DECISION DELEGATED TO HEAD OF PLANNING

Application No: H16-0334-24 **Applicant:** Mr A Quantrill

Proposal: Details of external boxes for gas & electricity supplies & gas flues & soil vent pipes, boundary treatments & site & floor levels (Conditions 3, 5 & 6 of H16-0748-21)

Location: Adjacent To 117 Albion Street Spalding Lincolnshire

DRG No. 33021/03

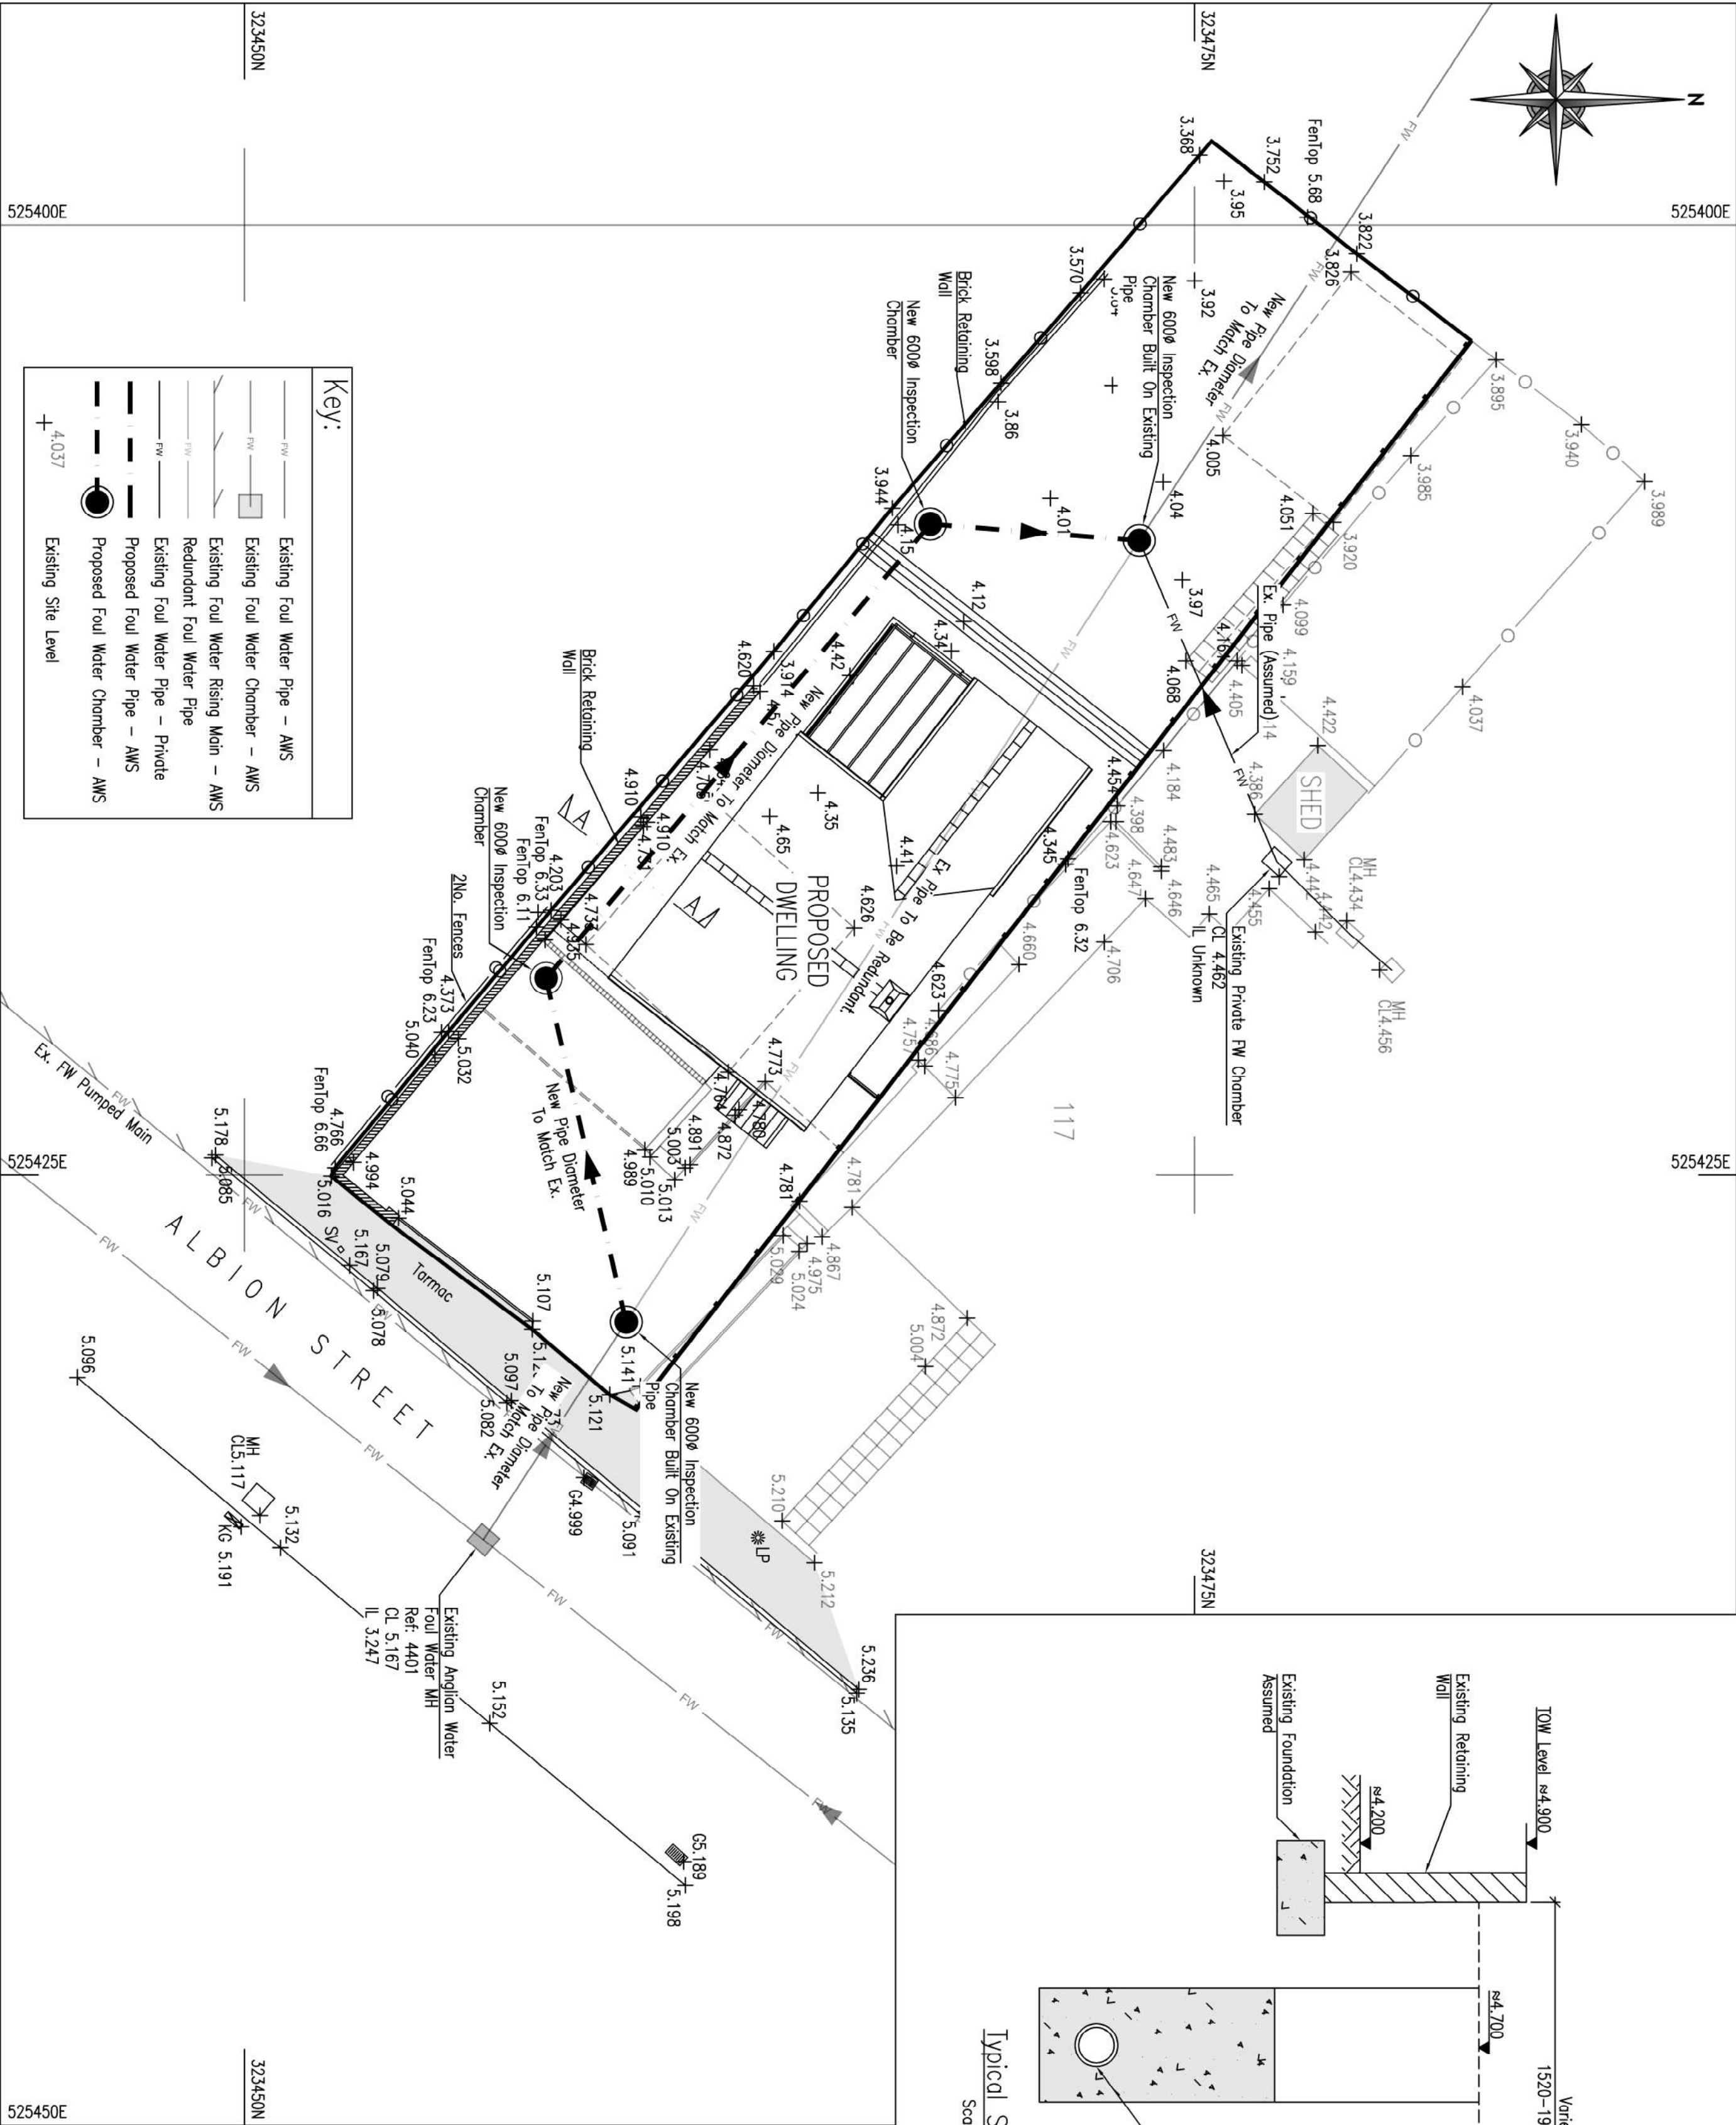
The existing ground level where the principal elevation of the dwelling would be located is between 4.93 and 4.773 metres ODN (going south to north); while the ground level where the rear of the dwelling would be located is currently set at 4.34 metres ODN. The angle of decrease between the two points is fairly consistent, although slightly more rapid along the southern boundary. The existing ground level at the roadside is approximately 5.107 metres ODN. The far rear of the site is set at 3.822 metres.

The proposed finished floor level of the dwelling is 5.31 metres ODN. The eastern section of the plot (where the dwelling is located) would be raised accordingly, to be set at 0.15 metres below finished floor levels or 5.16 metres ODN. This translates to a dwelling approximately 0.4 metres above existing ground level at the front of the site, and 0.97 metres above ground level at the rear of the house. That being said, the FFL would only be approximately 0.2 metres above ground level at the road.

Insufficient details floor or ground levels of adjacent plots have been submitted in order to enable an adequate comparative view. As such, the potential for overlooking or overshadowing arising from the raise in FFL cannot be fully assessed at this time. Condition 6 explicitly required the submission of cross-sectional drawings which have not been submitted here. Therefore, it is considered that the inadequate details have been provided to ensure no unacceptable amenity impacts would occur or to enable an informed decision by the LPA.

Insufficient evidence has been provided to discharge condition 6 of H16-0748-21.
